## **RE: SSDA 9726 - ROYAL HALL OF INDUSTRIES - RESPONSE TO REQUEST FOR ADDITIONAL INFORMATION**

We are writing on behalf of Sydney Swans Limited (**the proponent**) to address the issues raised in your request for information (**RFI**), dated 16 December 2019 relating to State Significant Development Application (**SSDA**) 9726 at the Royal Hall of Industries, 1 Driver Avenue, Moore Park. In response to the additional information requested, further clarification is now provided in connection with the matters raised. We trust that this will assist your assessment of the SSDA.

The SSDA seeks consent for the development and operation of a multi-purpose sport and community facility at the Royal Hall of Industries (**the project**). The proposal seeks to adaptively reuse the Royal Hall of Industries, develop a two-storey high-performance sports building, and increase the permeability and amenity of the site through improvement to existing entries and public domain improvements.

RHI & SWIFTS BUILDING ELEVATIONS
EAST - WEST

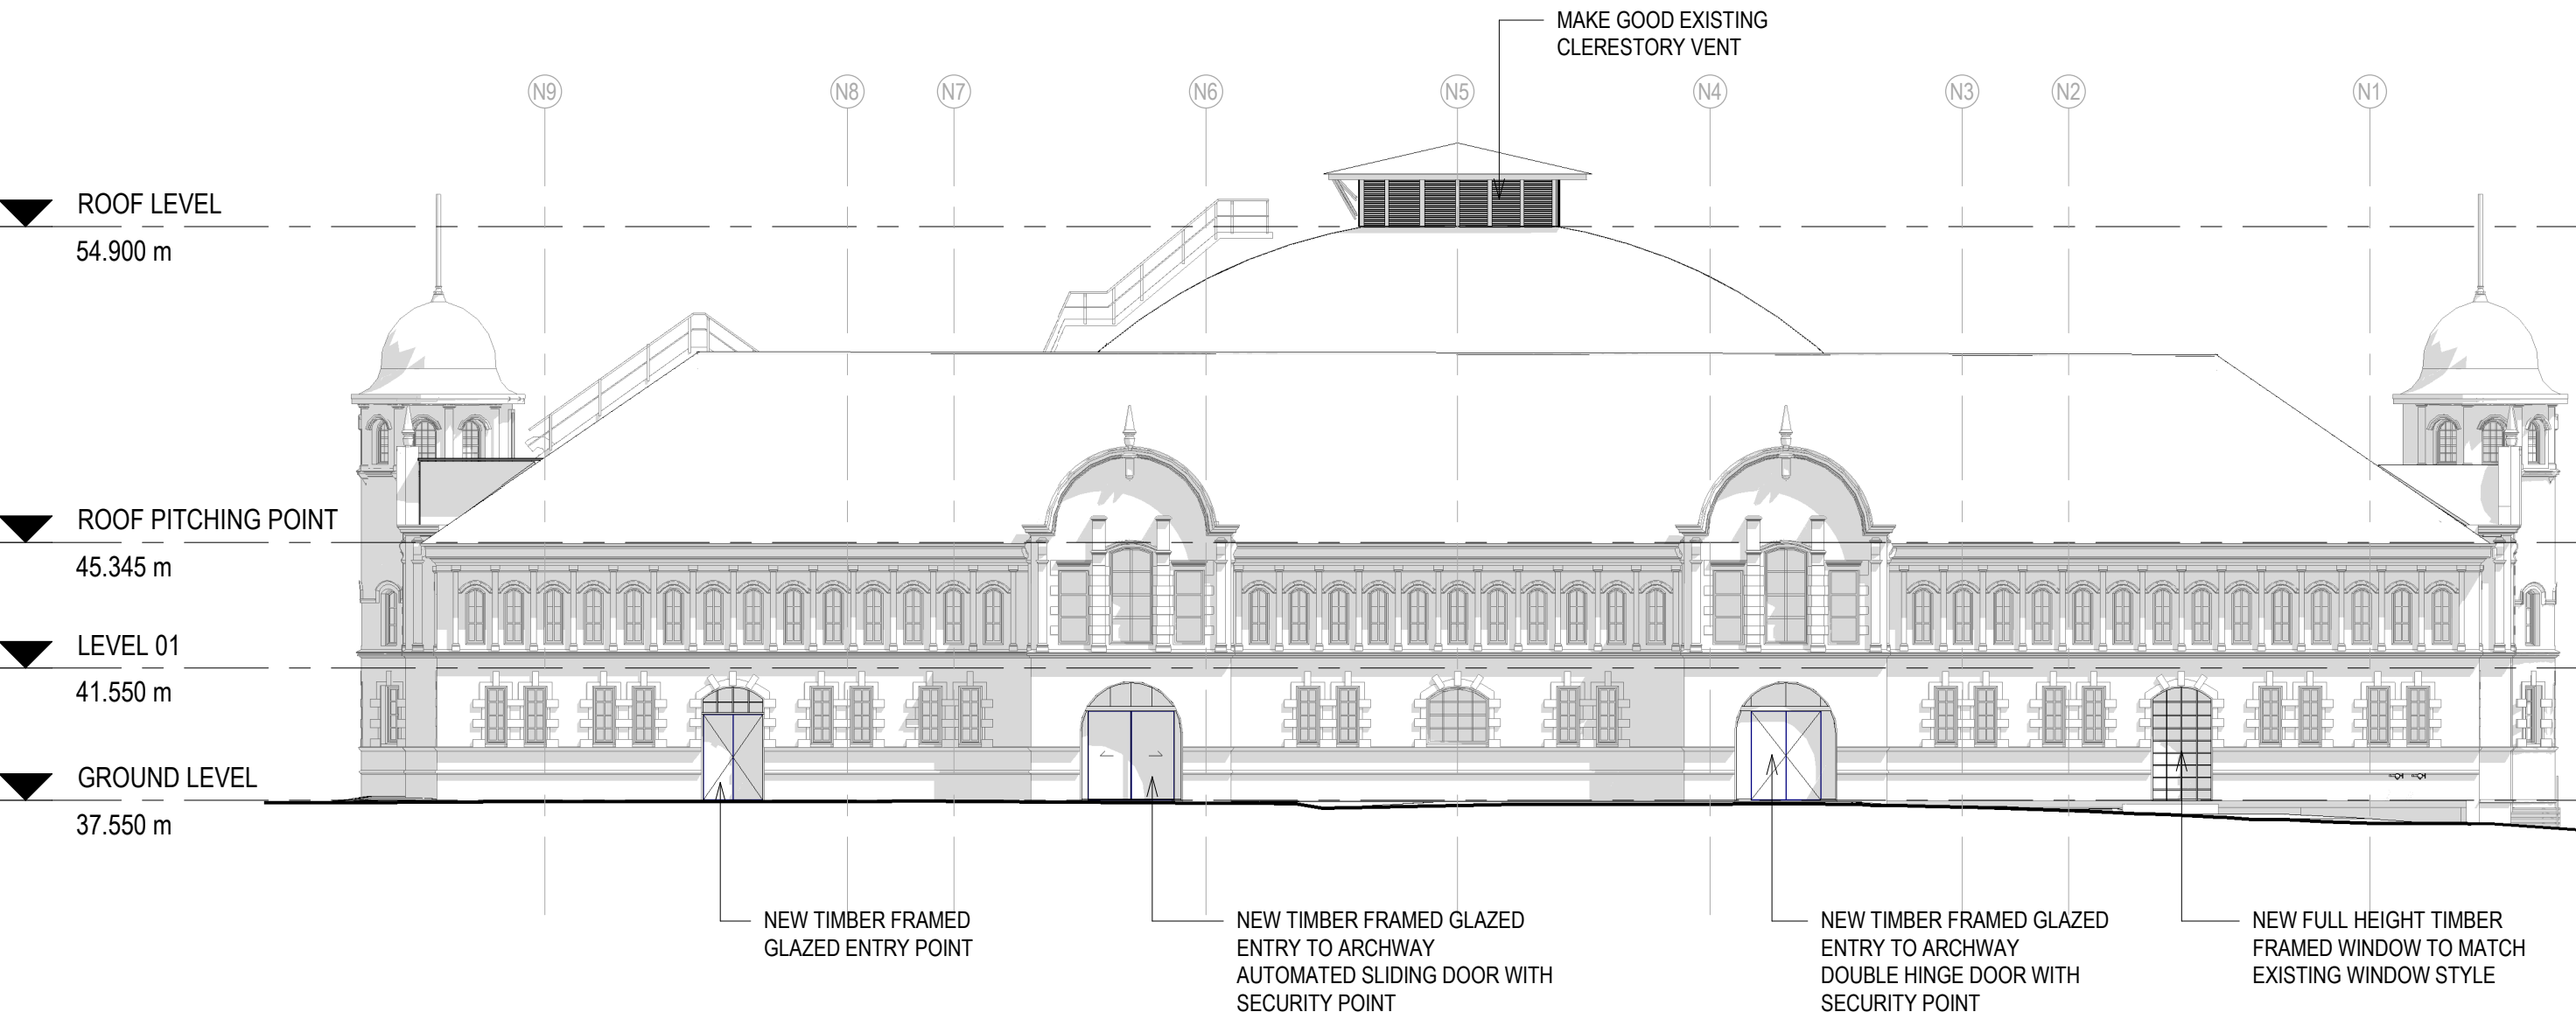
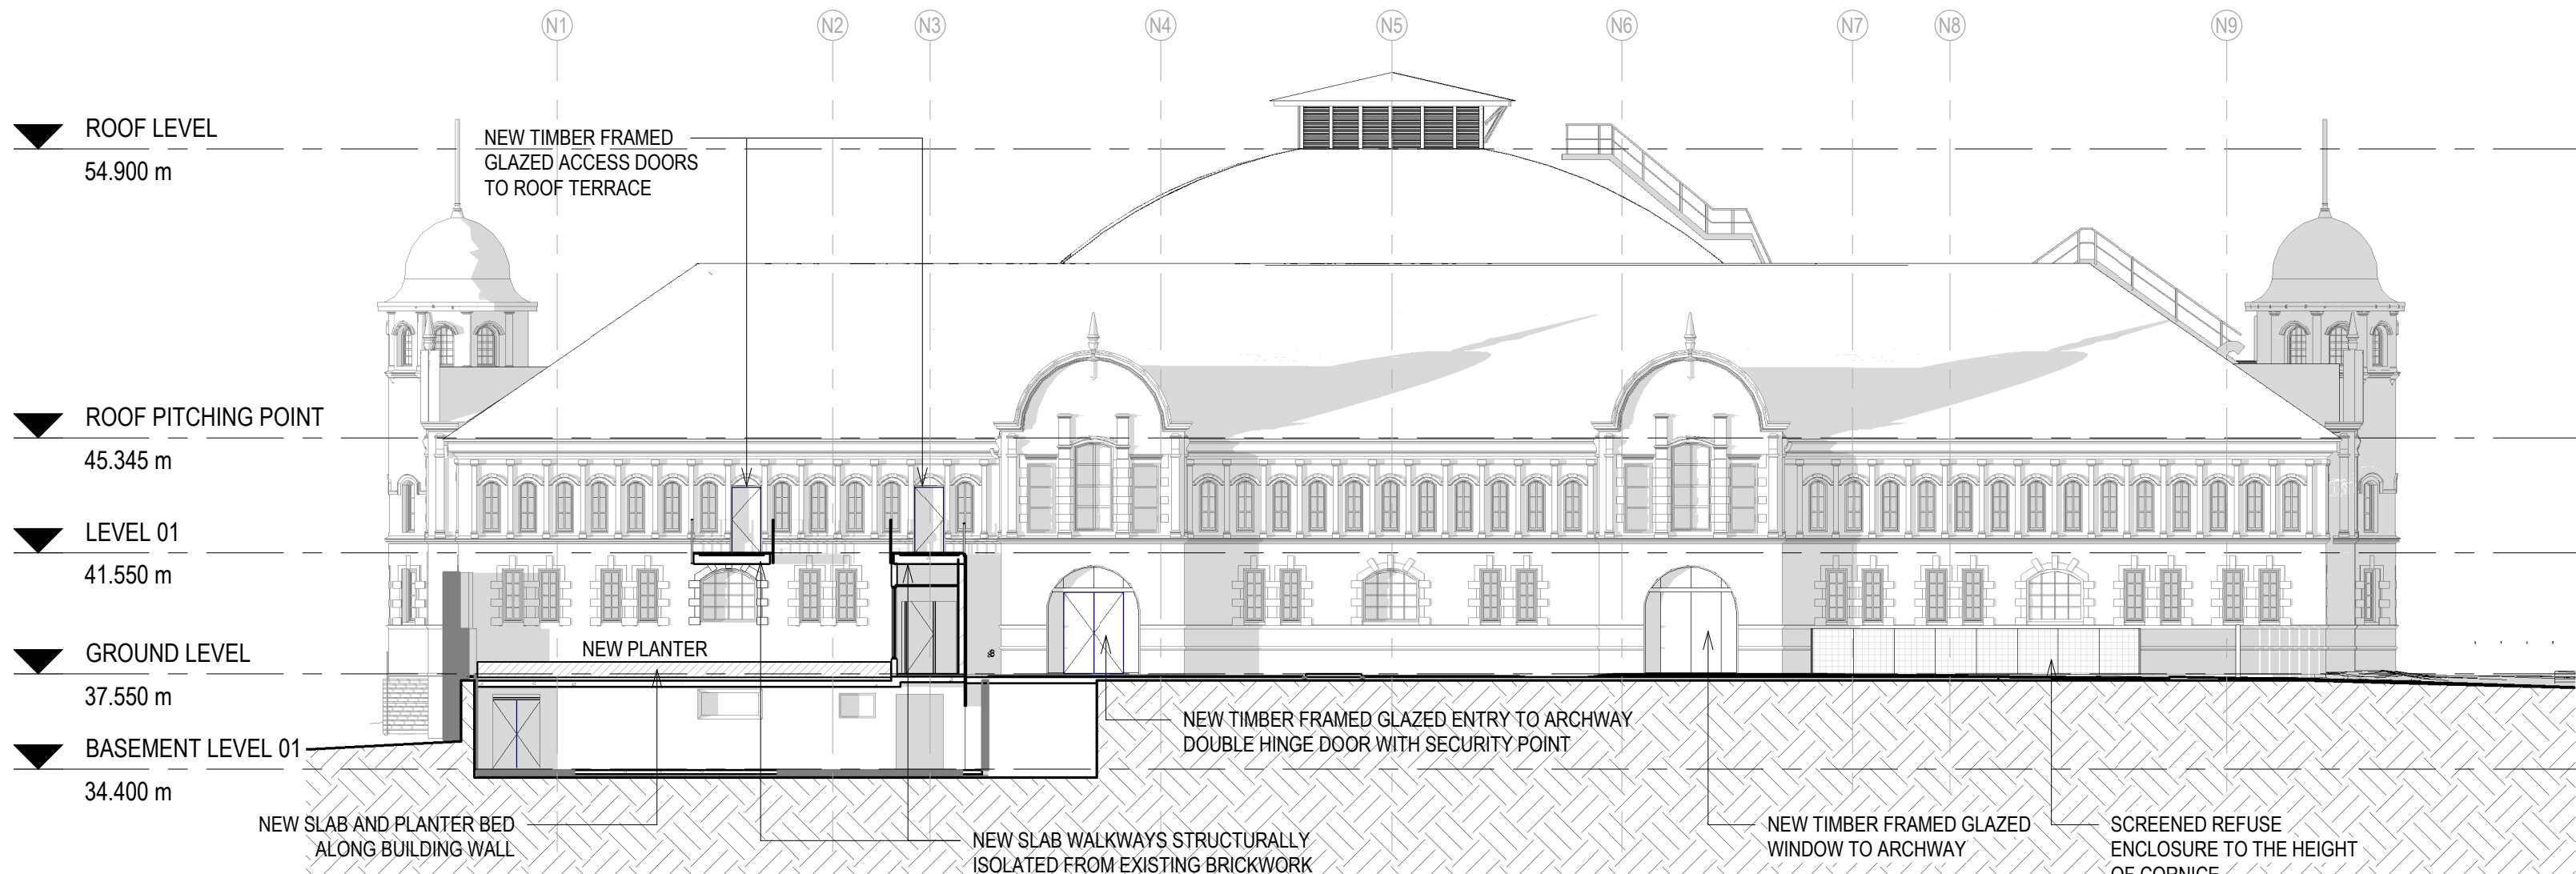
Agency Comments	Proponent Response
<b>Department of Planning, Industry and Environment</b>	
<p><i>NSB Building</i></p> <p><i>Reconsider the approach to the first-floor façade of the Errol Flynn Boulevard elevation including options to increase vertical articulation.</i></p>	<p>This matter is discussed in detail within <b>Attachment A</b>. The issue of vertical articulation on the New South Wales Swifts Building has been addressed through the addition of a new awning and vertical fins over the double height wall on the entry foyer of the building. This is designed to closely mimic the rhythm of the RHI's upper window mouldings.</p> <p>As such, this responds to previous comments made during the State Design Review Panel (SDRP) process seeking to articulate the administrative element of the building. These comments were initially recorded by Urbis in the meeting notes taken at the SDRP meeting on 10<sup>th</sup> April 2019 as per <b>Attachment H</b>.</p>

Appendix A; Plan, Potential Crossover Location relative to trees No. 42-46

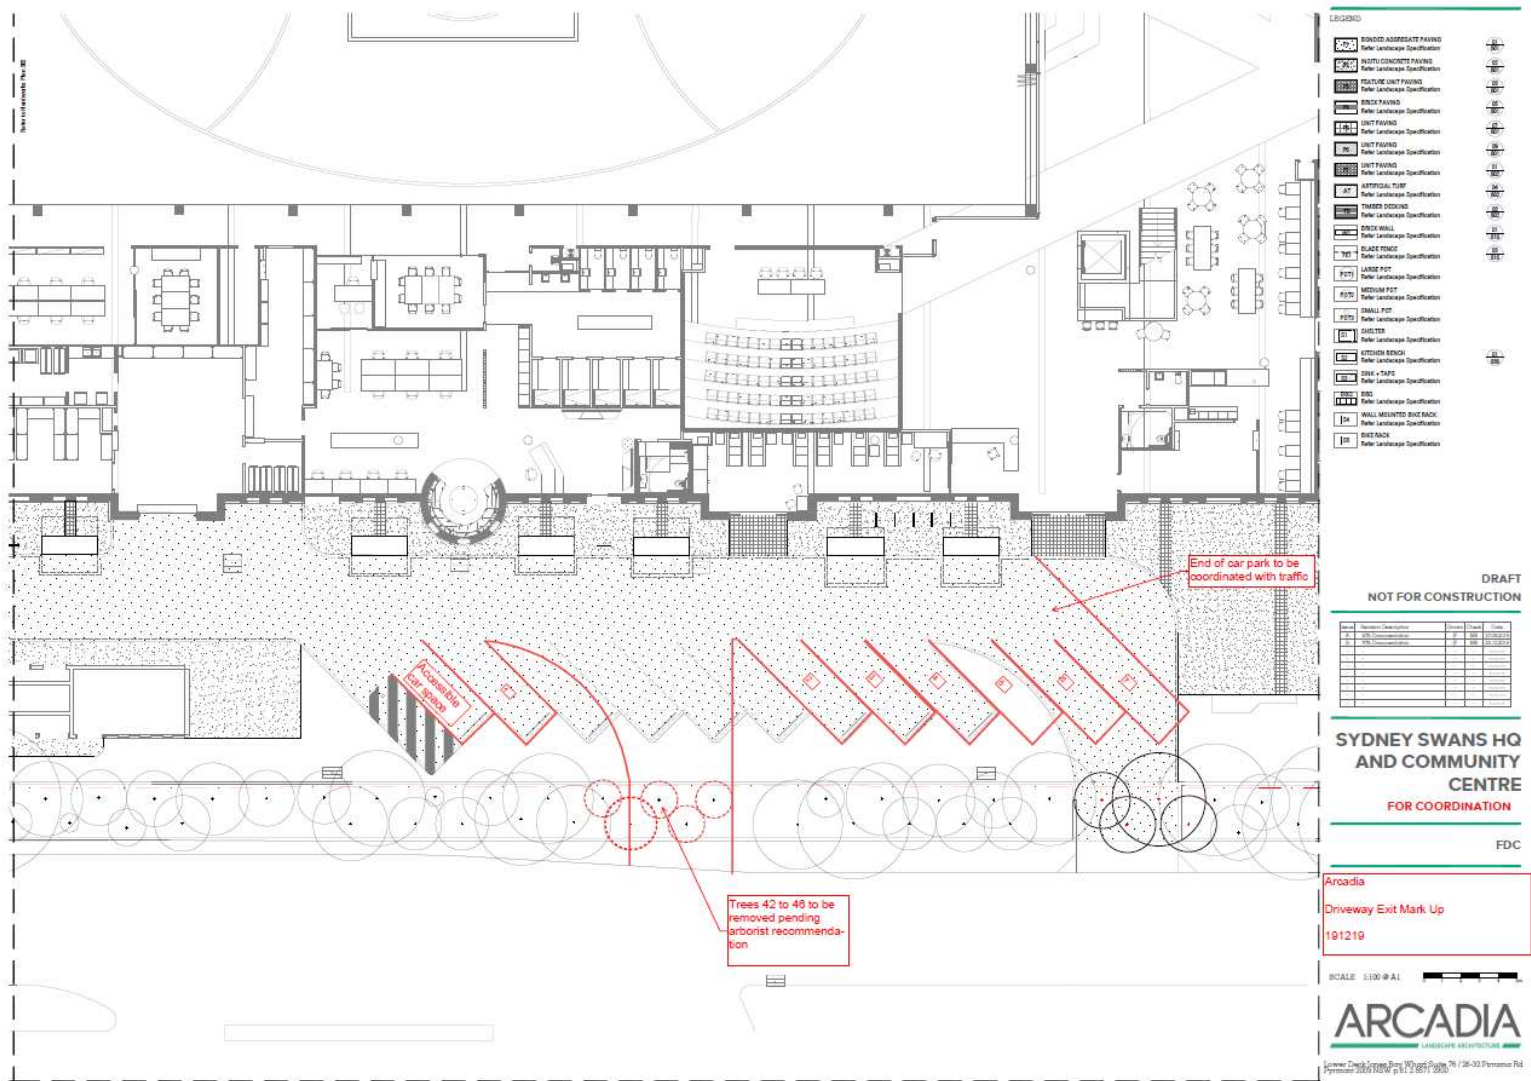
<p><b>Tree Removal</b></p> <p><i>The City reiterates that Trees 58, 59 and 60 on Errol Flynn Boulevard must be retained. The trees are semi mature to mature healthy trees with a medium landscape significance rating. The trees form part of a group of planting along Errol Flynn Boulevard that make a positive contribution to the landscape.</i></p>	<p>As identified within the RTS, these trees are required to be removed to facilitate a vehicular exit point. If this was removed, this would require vehicles to exit via the public plaza, or alternatively exit via the entrance, which would have unacceptable safety impacts.</p> <p>The proponent originally investigated alternative options for the vehicular crossover, including relocating of the crossover further north. However, this was determined to generate a greater level of impact on tree retention.</p> <p>The proponent therefore sought to progress with the design option that has the least impact on trees and safety.</p>

Agency Comments	Proponent Response
<p><i>Further, the proposed north-eastern driveway cross over for the car park exit will have a significant encroachment within the TPZ of Trees 56 and 61. As an alternative, it is suggested that the proposed north-eastern driveway crossover be amended to utilise existing crossovers or be relocated so that a section of trees with lesser value, size and health be removed instead. As such, consideration should be made to Trees 42-46, which are of less significance and remove Tree 43 and 45.</i></p>	<p>This proposed alternative arrangement has been explored by the project team.</p> <p>Firstly, it is the case that both groups of trees are considered from an arboricultural perspective to have an equivalent significance, meaning that no difference exists regarding the loss of either trees No. 43-46 or 58-60 (see the Arborist Response at <b>Attachment F</b>). Therefore, the design should be influenced by the practical location for the cross-over.</p> <p>Secondly, as advised by GTA within <b>Attachment E</b>, it is considered that an exit driveway in the location of trees 42 to 46 would introduce conflict with the existing multi-deck car park access on the opposite side of Errol Flynn Boulevard. In this scenario, vehicles would theoretically be able to exit the RHI site and turn right onto Errol Flynn Boulevard using the break in the central median at the multi-deck car park access, which would create conflict with traffic egressing the multi-deck car park. Whereas, the proposed exit driveway in the location of trees 56 to 61 (where currently proposed) avoids this conflict.</p>

Photos of test pits; Test Pit 2

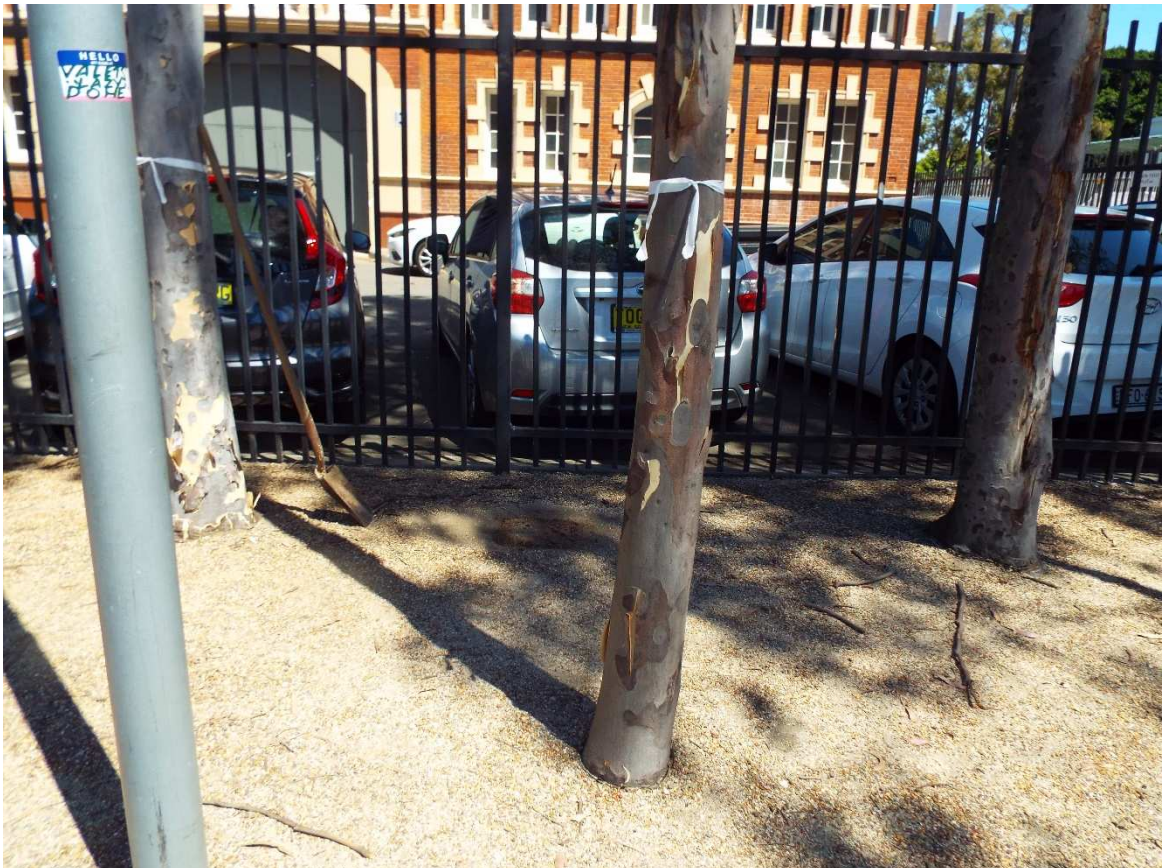
<p><i>It should be noted that the photos of excavation (test pits) within the TPZ of Trees 56-61 have not been provided. Observation 4 of the Arborist Addendum states that the photos are available on request. These photos must be submitted to assess the impacts of excavation</i></p>	<p>Photos of the on-site excavation (test pits) prepared by Allied Tree Consultancy have been provided at <b>Attachment F</b>.</p>
<p><i>Additionally, it is recommended that only minor pruning of less than 10% of street Trees 8 and 9 be undertaken. It is reiterated that all trees surrounding</i></p>	<p>Construction of the project will require pruning of two trees located on Lang Road adjacent to the southern boundary, as the proposed NSB will conflict with a portion of dripline. The extent of the pruning (20% of tree 8 and 13% of tree 9) is not considered a detriment to the trees.</p>
